From: Maria Tomalova <Maria.Tomalova@arun.gov.uk>
Sent: Wednesday, September 13, 2023 5:52 PM
To: Planning.Responses <Planning.Responses@arun.gov.uk>
Subject: FW: Stakers Farm

From: Martyn White <Martyn.White@arun.gov.uk>
Sent: Thursday, June 18, 2020 11:07 AM
To: Maria Tomalova <Maria.Tomalova@arun.gov.uk>
Subject: RE: Stakers Farm

Site Layout

Drawing Title
Proposed Plans - Barn 1

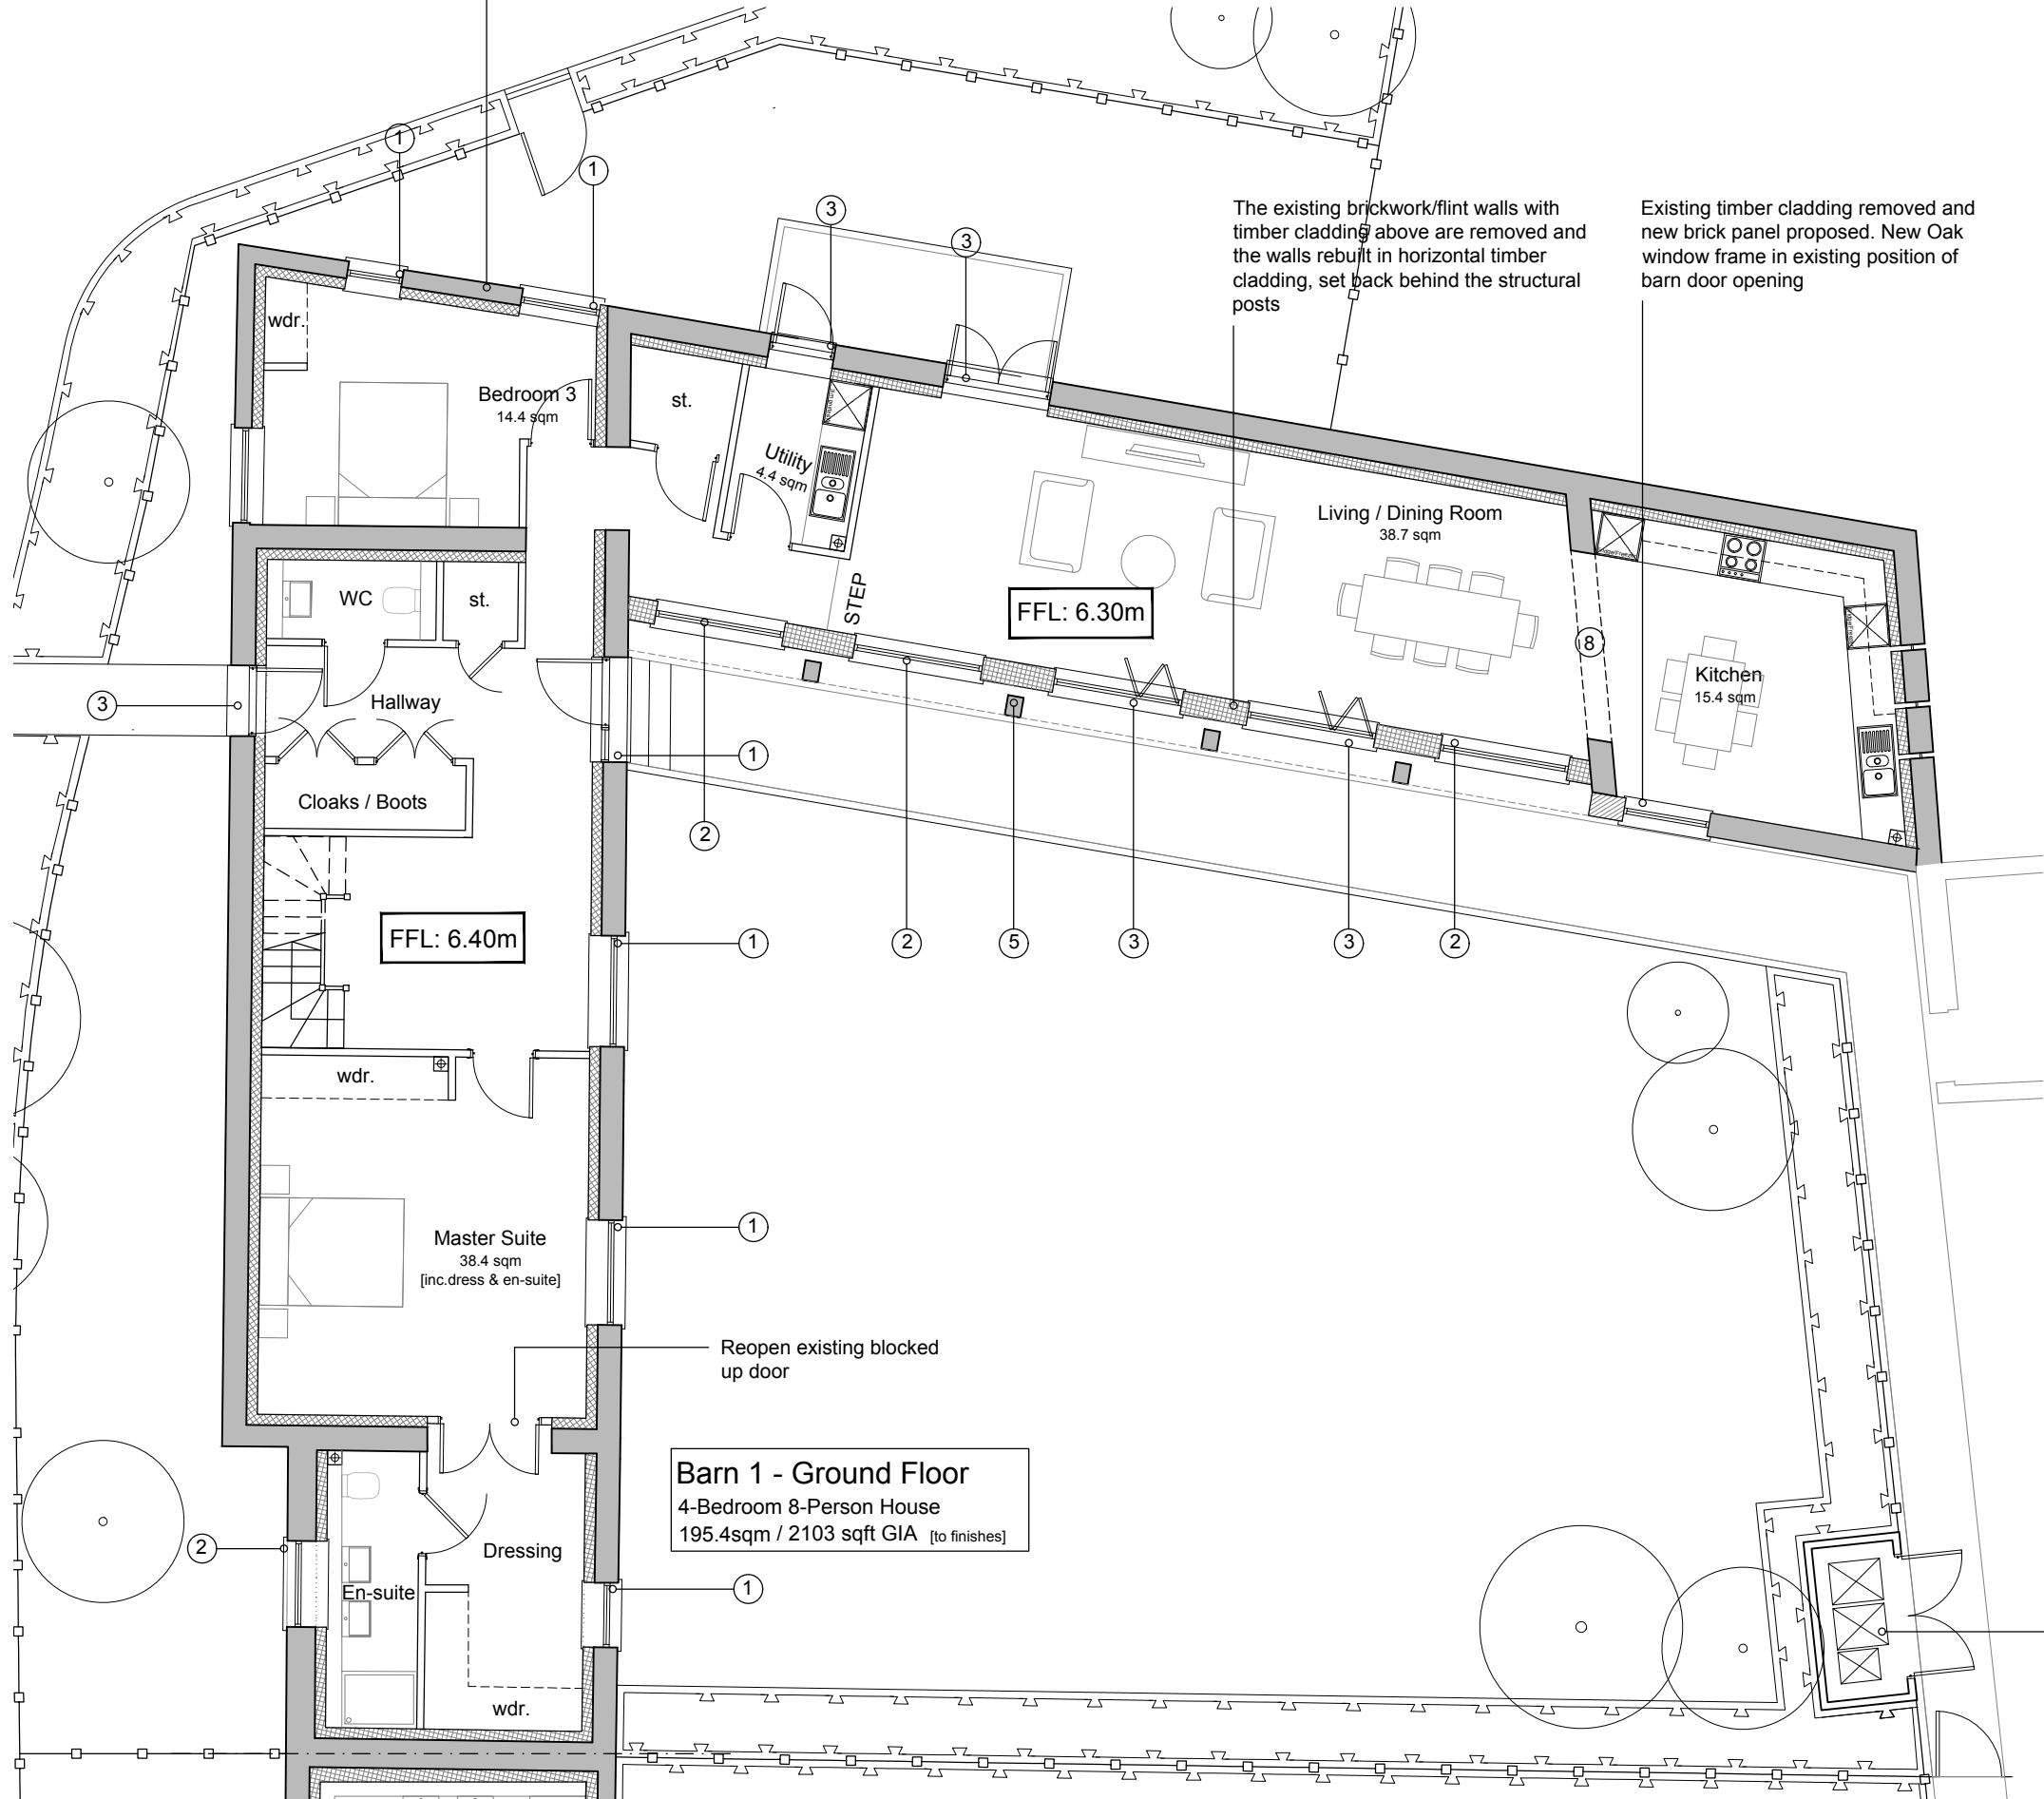
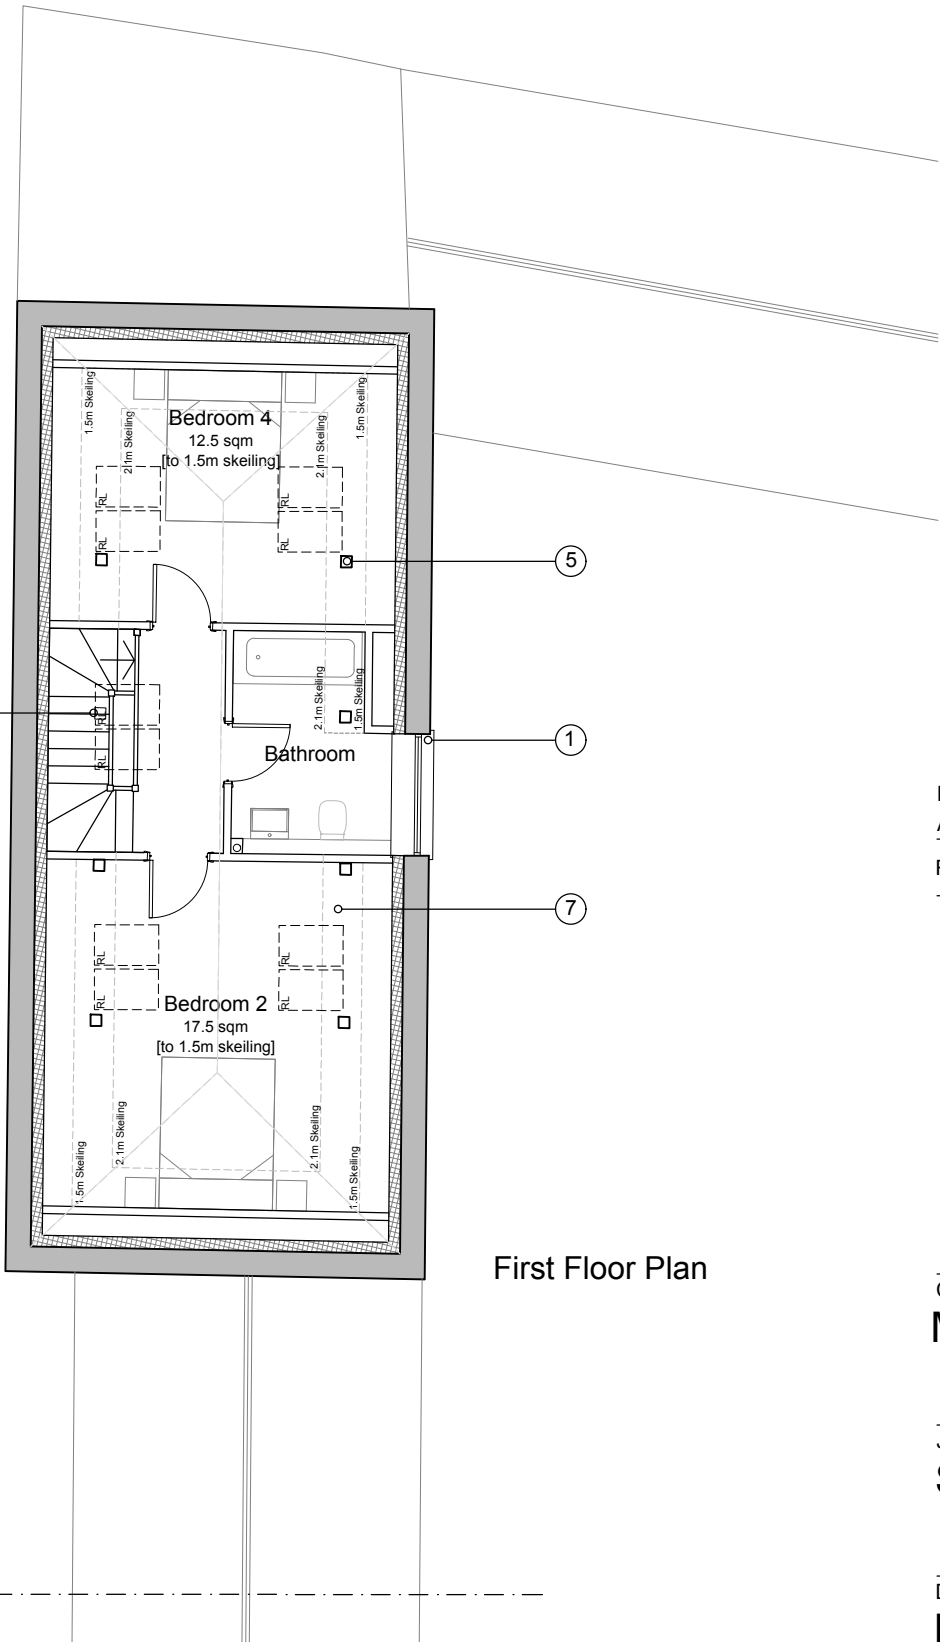
- Amendments to the site layout so that the courtyard area to the east of barns 1 and 2 is used for car parking rather than used as garden space. – this is positive. The courtyard should also form the main entrances to barns one and two. The courtyards should retain their existing open, hardscaped characteristic.
- Deletion of the proposed car barns at the north of the site and the vehicular access to these barns, and provision of amenity space for barns 1 and 2 to the rear (west). This is acceptable, subject to details of the areas to be provided as amenity space and the details of any fencing

We will remove as many rooflights as possible from this barn. However, we cannot remove all the rooflights as we will need to provide light to the bedroom to make it a habitable space. A roof light will also be required to provide purge ventilation (Part F of Building Regs) otherwise a mechanical system would be needed. Under the Building Regulations we will also need to meet the Daylight and room brightness guidance set within British Standard BS 8206-2:2008 Lighting for Buildings. We will therefore seek to provide the very minimum amount of rooflights necessary to meet Building Regulations and seek to locate them on the least prominent part of the roof. Such an approach would be in accordance with Historic England guidance 'Adapting Traditional Farm Buildings' which states the following:

There should be as few rooflights as possible, and these should be placed on the rear elevations where they will not be visible. They should also be of conservation standard

It is not clear how the interior of the barn will be treated, bearing in mind the comments I previously made regarding the interior. This needs careful consideration and more information to be supplied to us

'Where rooflights are to be added it is often better to locate them on the least prominent roof-slope when viewed from a public vantage point. It is always preferable to use the flush 'conservation type' roof lights as these have less impact on the roof surface, particularly if non-reflective glass is used.'

Drawing Title
Existing and Proposed Elevations - Barn 1

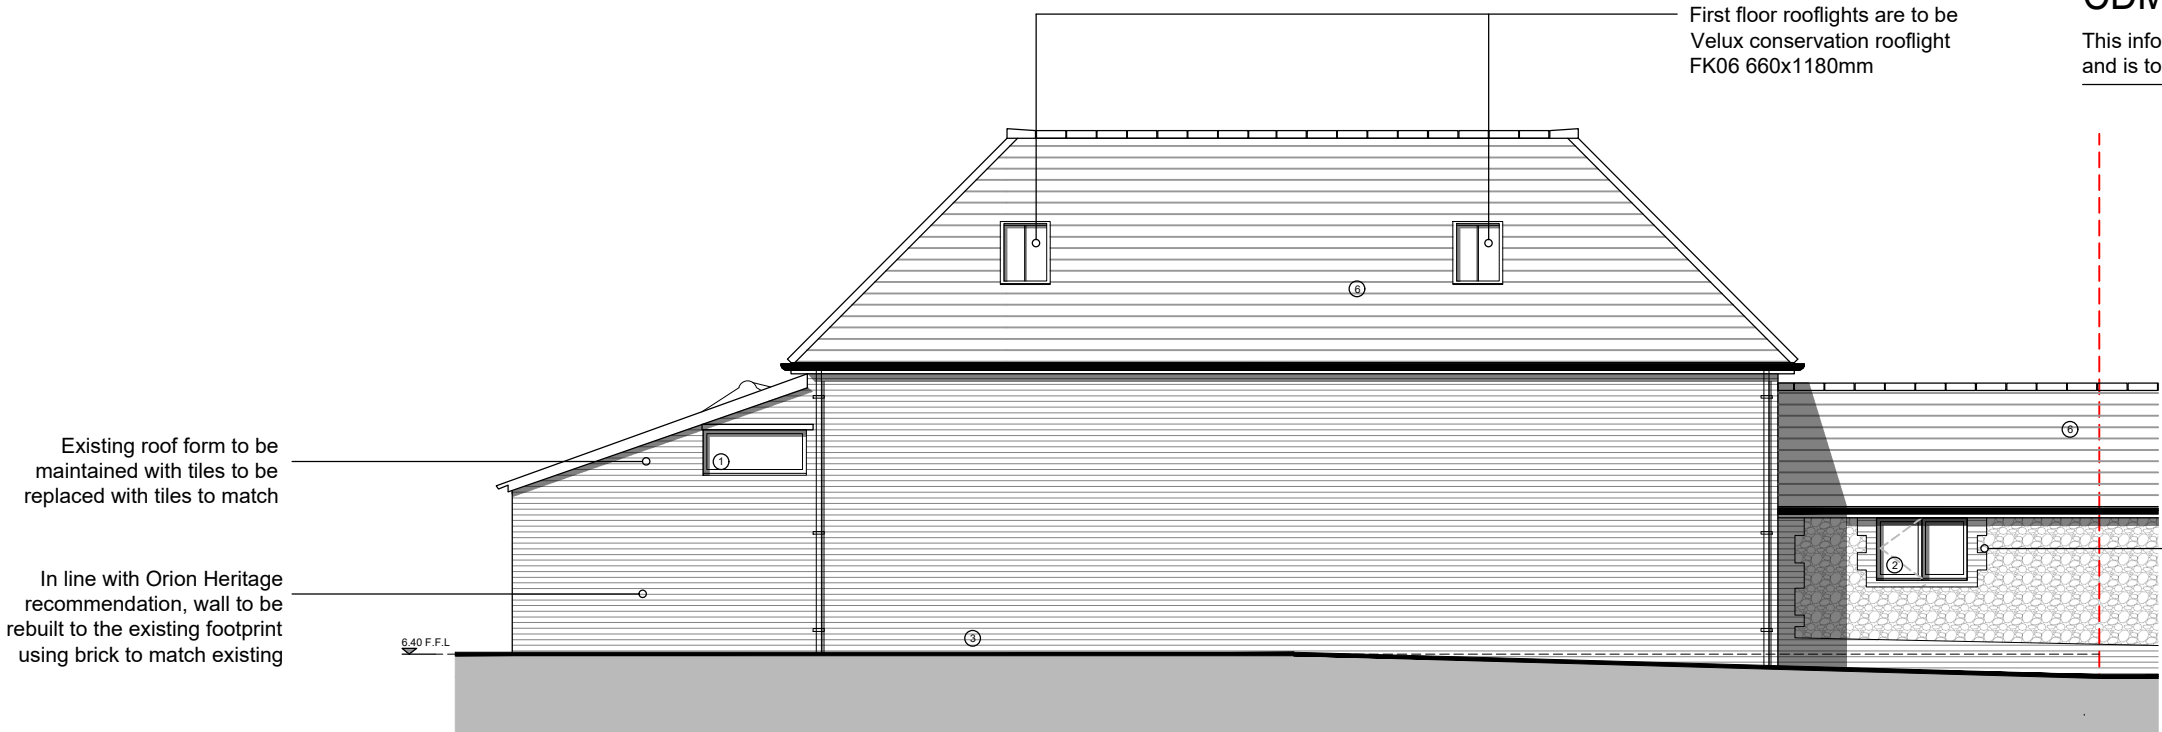
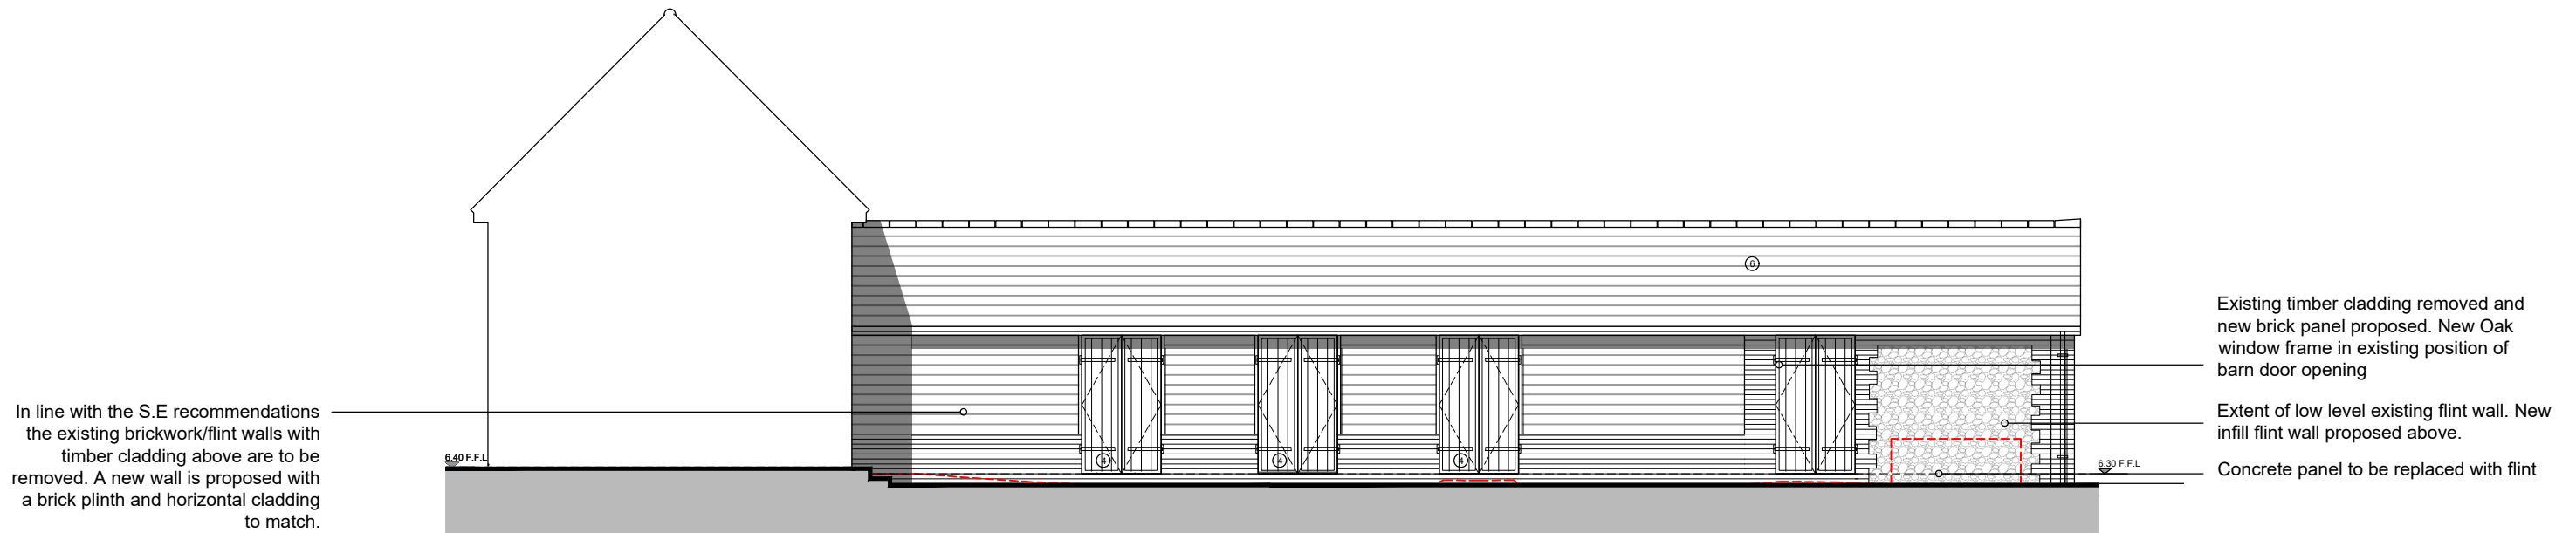
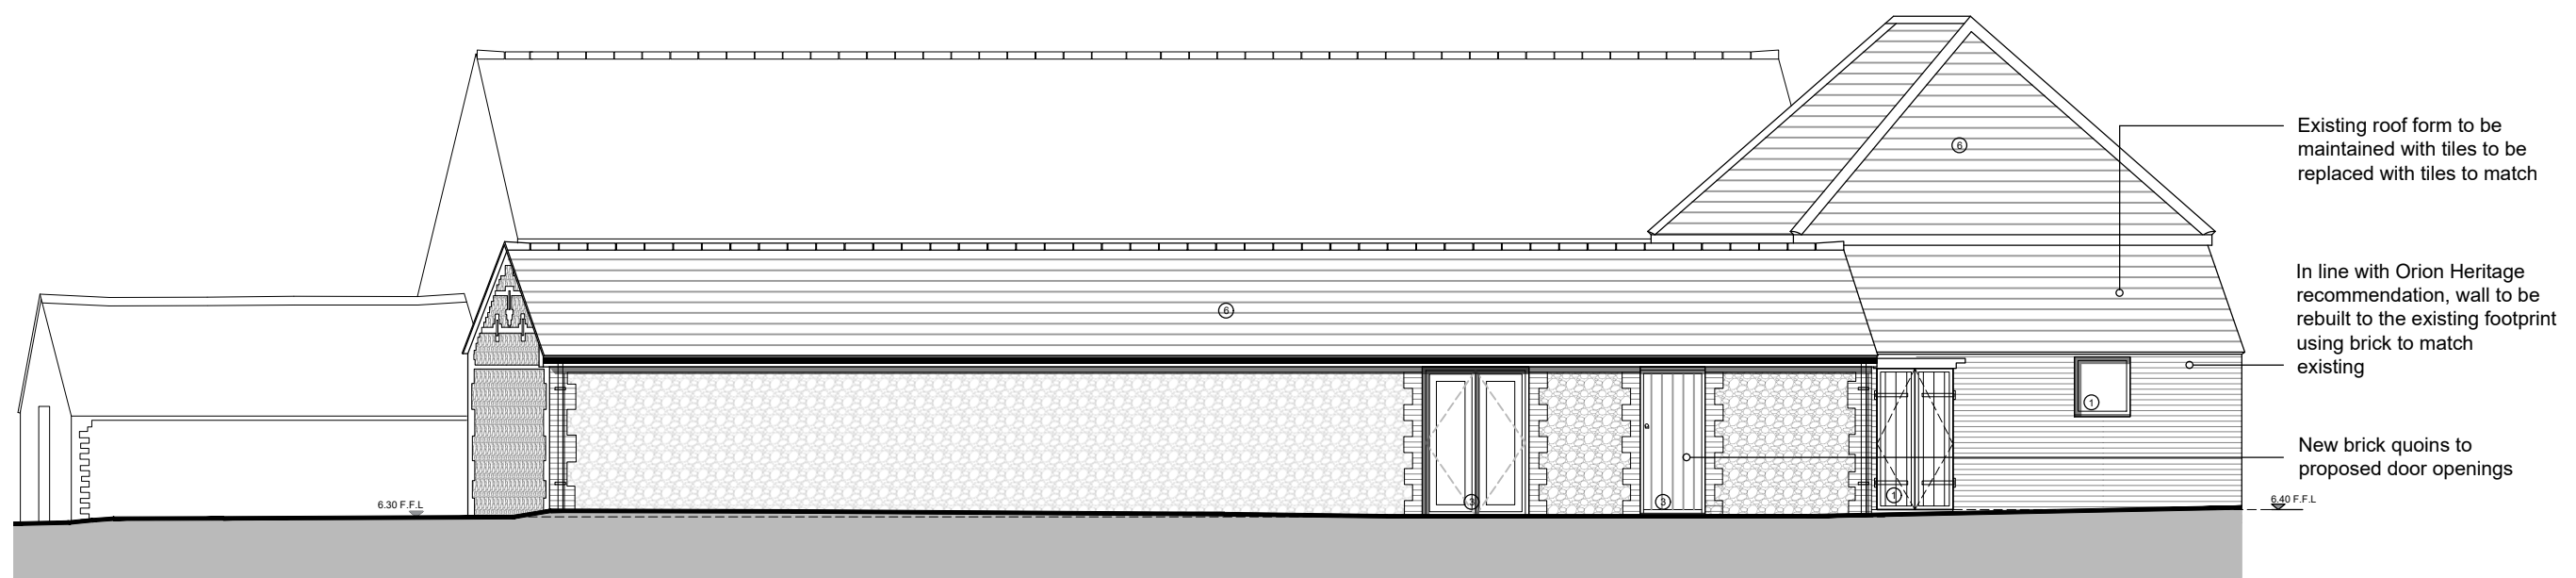
South elevation – we will amend the proposed alterations to the single storey element and reduce the amount of glazing, ensuring that this elevation is changed as little as possible from the existing situation.
